Att Ms. Linda Griffiths
Principal Planning Officer (Major Developments)
Cherwell District Council
Bodicote House Bodicote
Banbury OX15 4AA

Cherwell Planning 21/04179/LB and 21/04202/F

The application 21/04179/LB for a Listed Building Consent relates to the remedial works required to Trelawn House, in association with the larger application submitted for the redevelopment of the former Buzz Bingo site for 80 retirement living apartments. That application, 21/04202/F, refers to: Redevelopment for 80 retirement living apartments including communal facilities, access, car parking and landscaping.

PA21 Site Plan

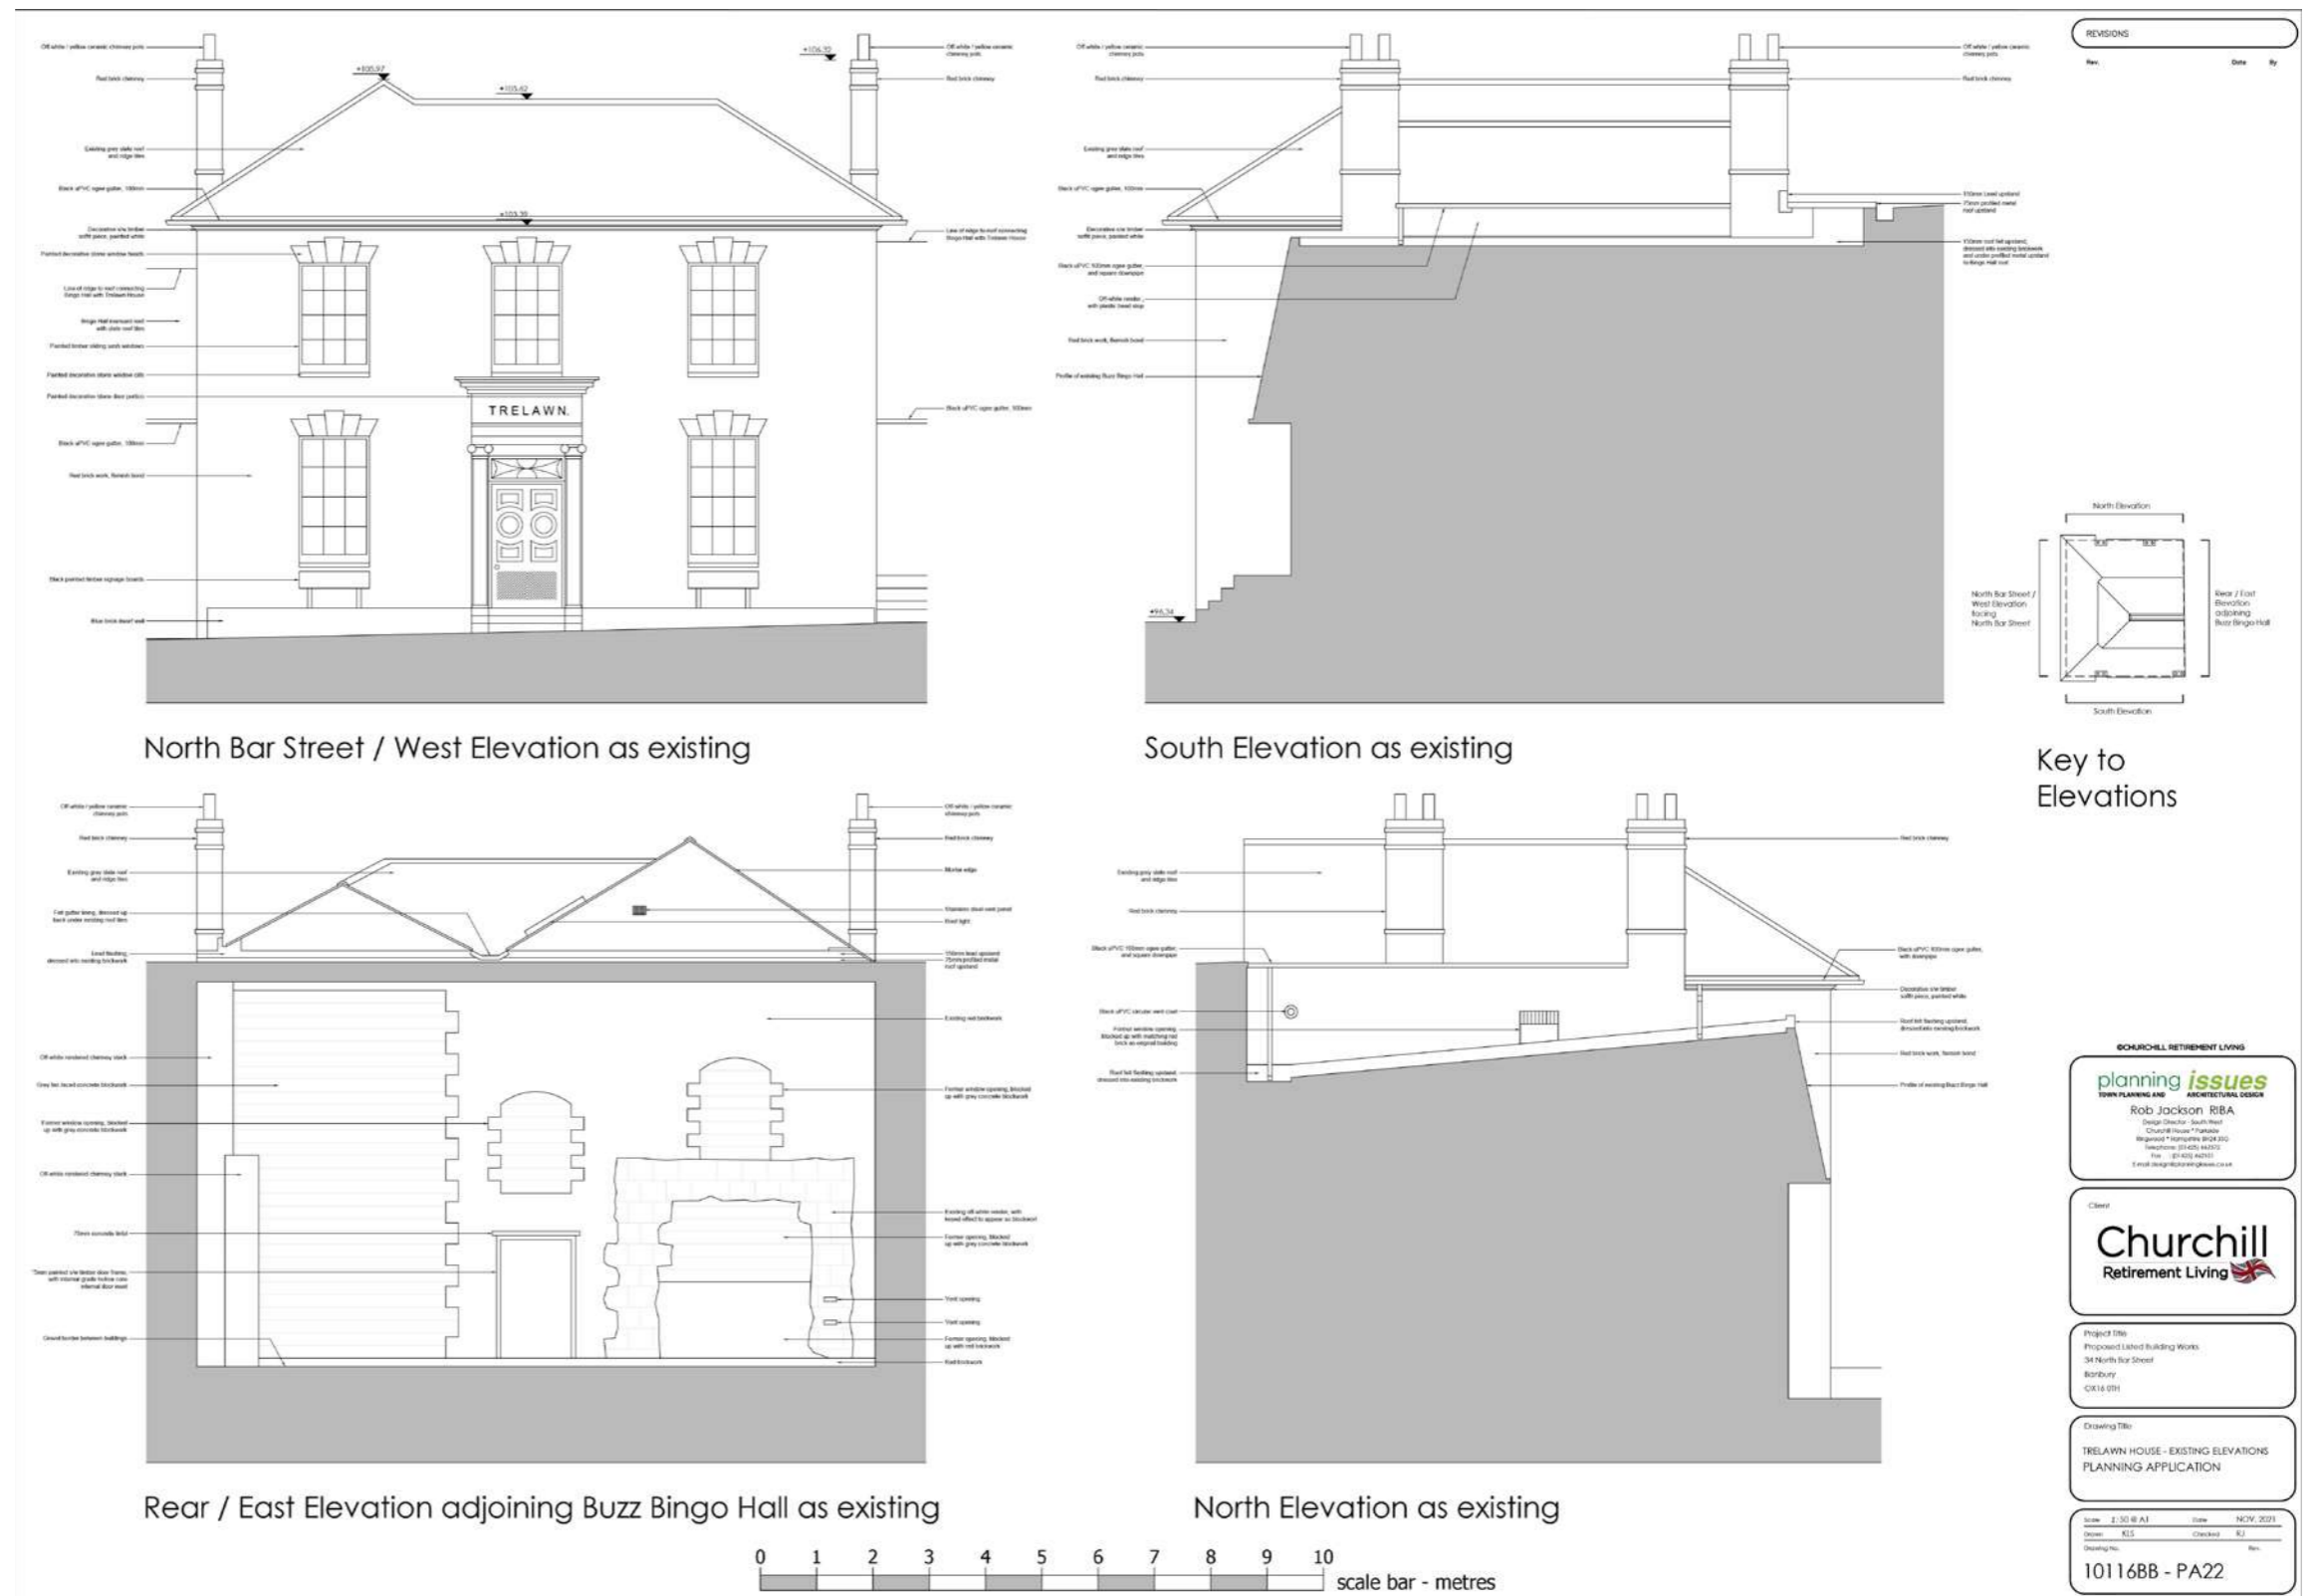
The proposed development is not sufficiently set back from the listed building to achieve an effective separation, leaving less than one meter gap to rear and southern façades of the building.

The design of the proposed south western part of the new development dwarfs the listed property, and by its scale will draw attention away from Trelawn, overshadowing and providing a pastiche of the former historic streetscape and building line.

PA23 Works as Proposed

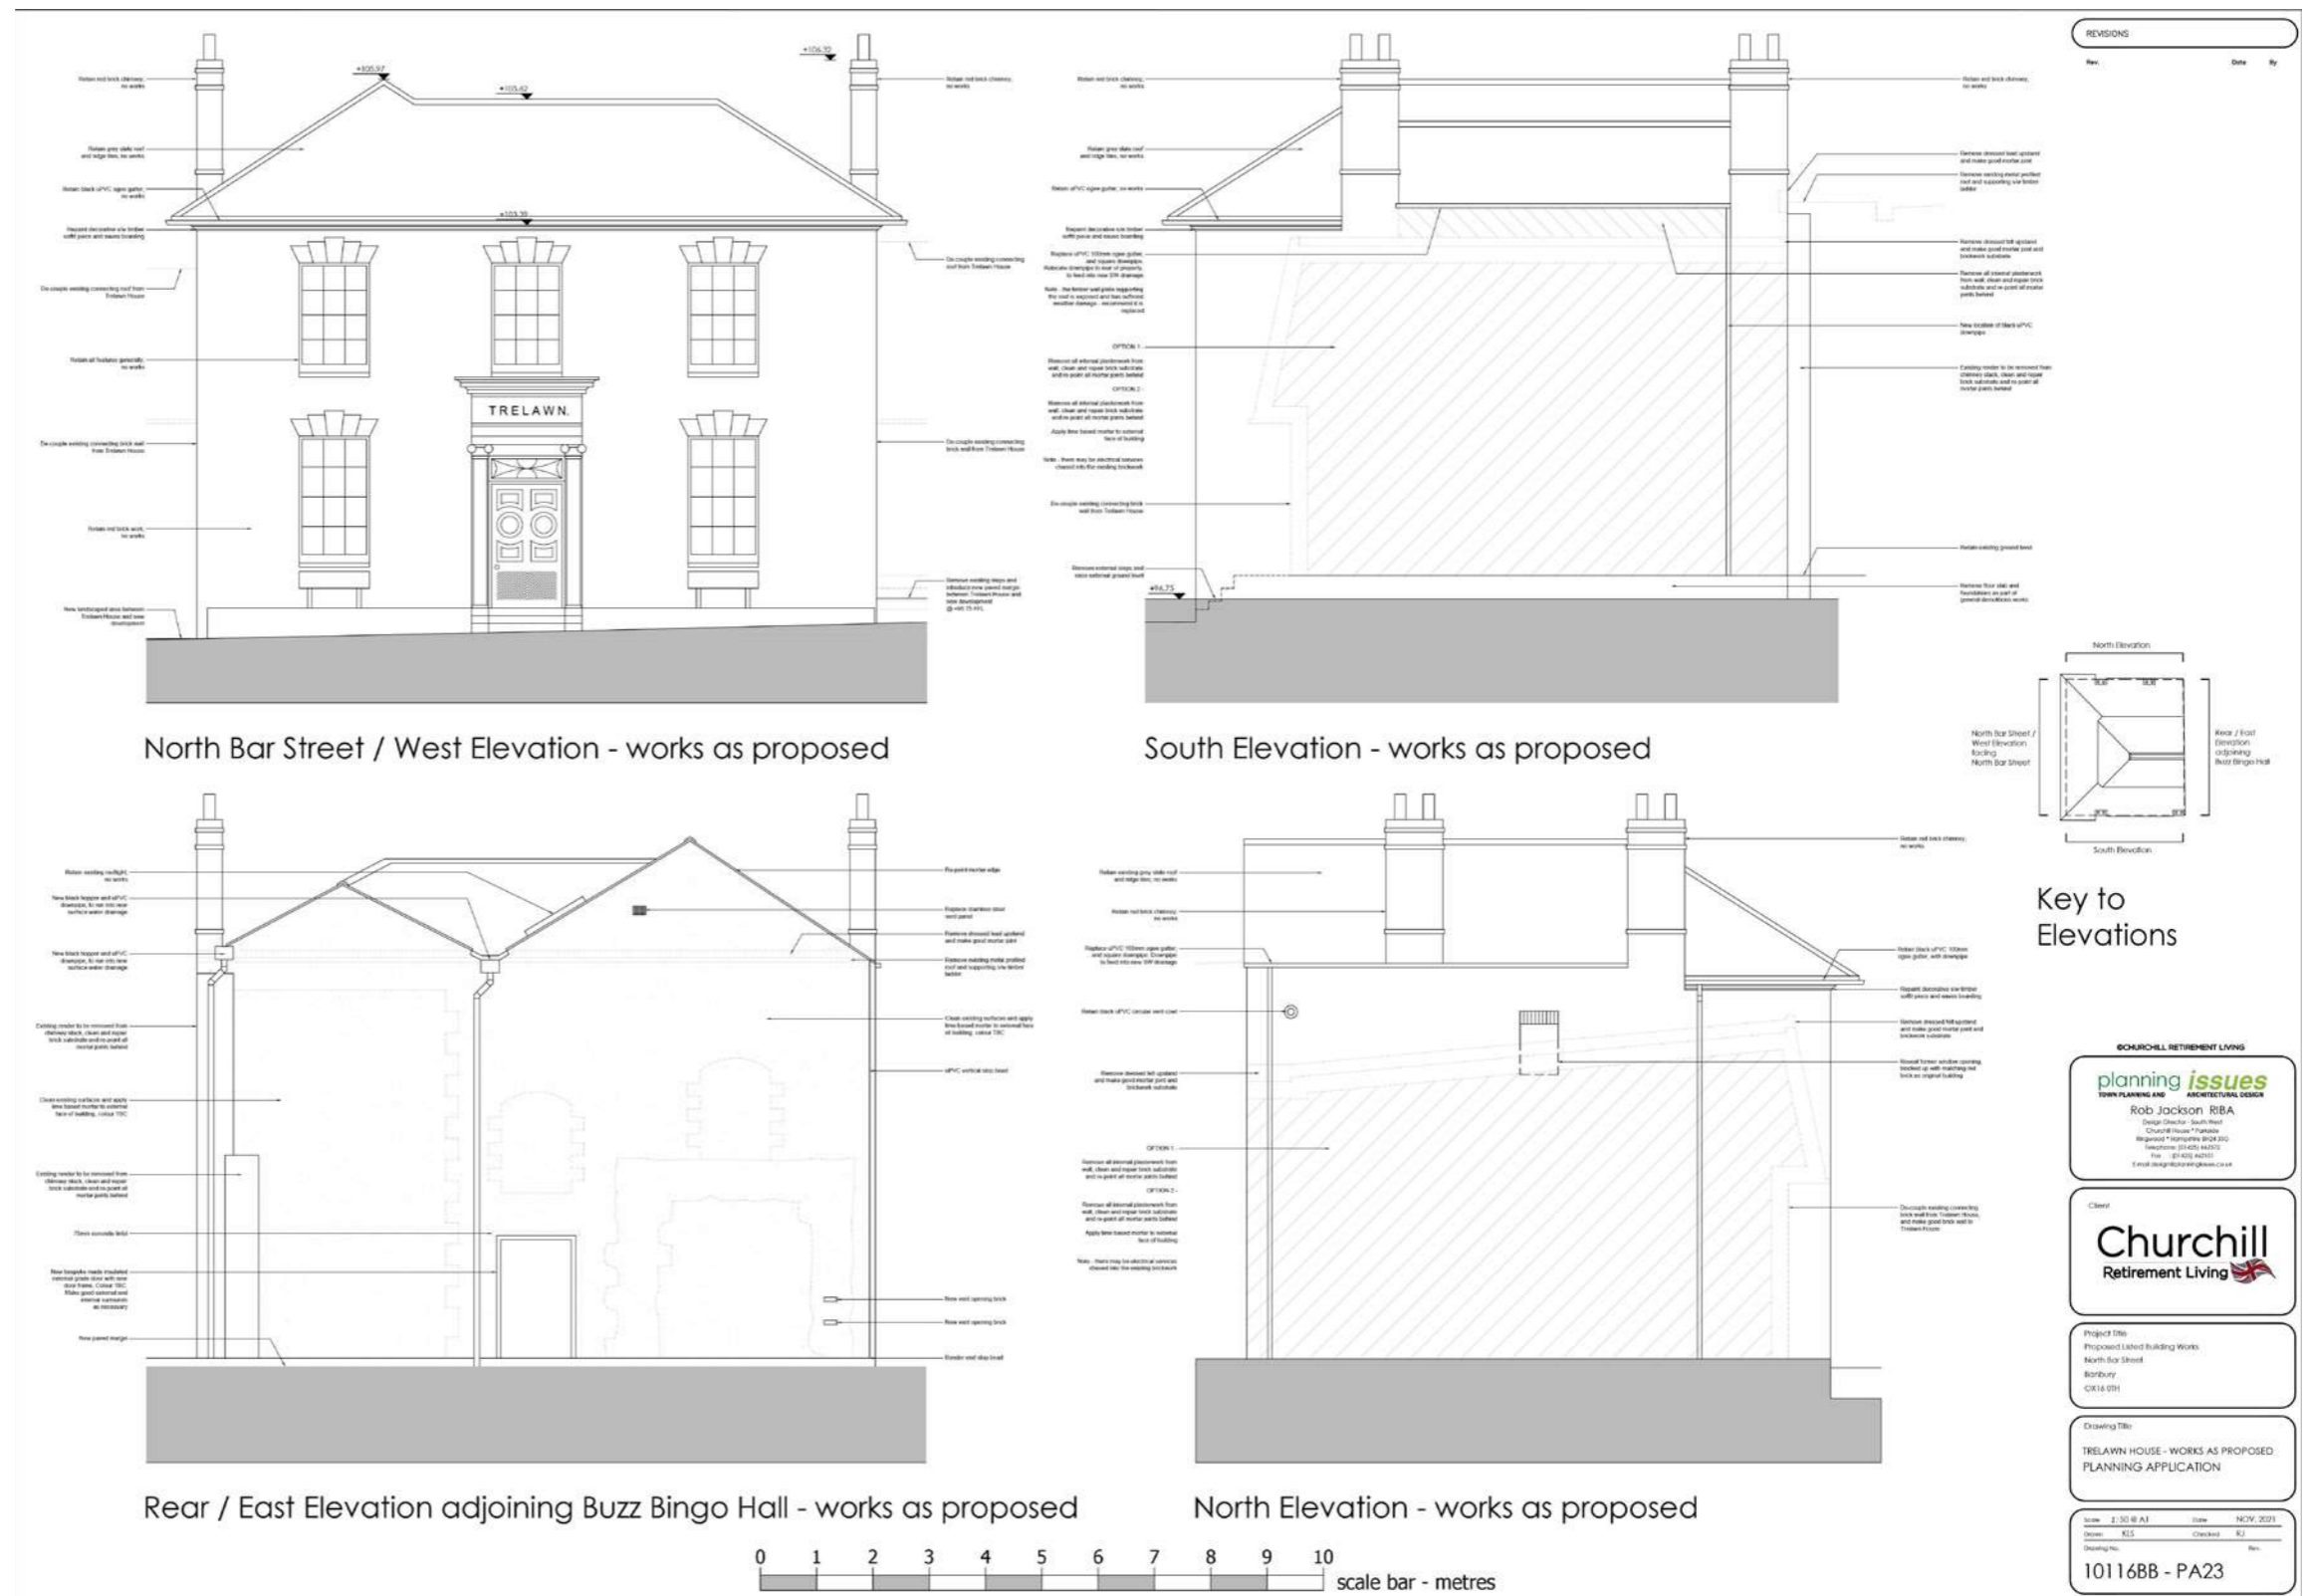
I do welcome reinstating views towards the northern elevation, yet express my strong concern regarding the proposed treatment on the northern face of the handmade listed brick. The proposed application of an external lime mortar render coat is totally contrary to the character of the property, and will destroy the integrity and historic character of the exposed elevation.

The elevation has historically faced the site corner and had openings, which could be now reinstated. The historic handmade brick should be repointed, restored and remain exposed as per original building settings.

I note that the applicant has also indicated that they intend to 'repair' and reinstate the exposed side elevation of Trelawn House with a render finish. This is a wholly inappropriate external treatment of the Listed Building (it was originally a fine freestanding brick built building), which should be identified to be restored with appropriate high quality brick.
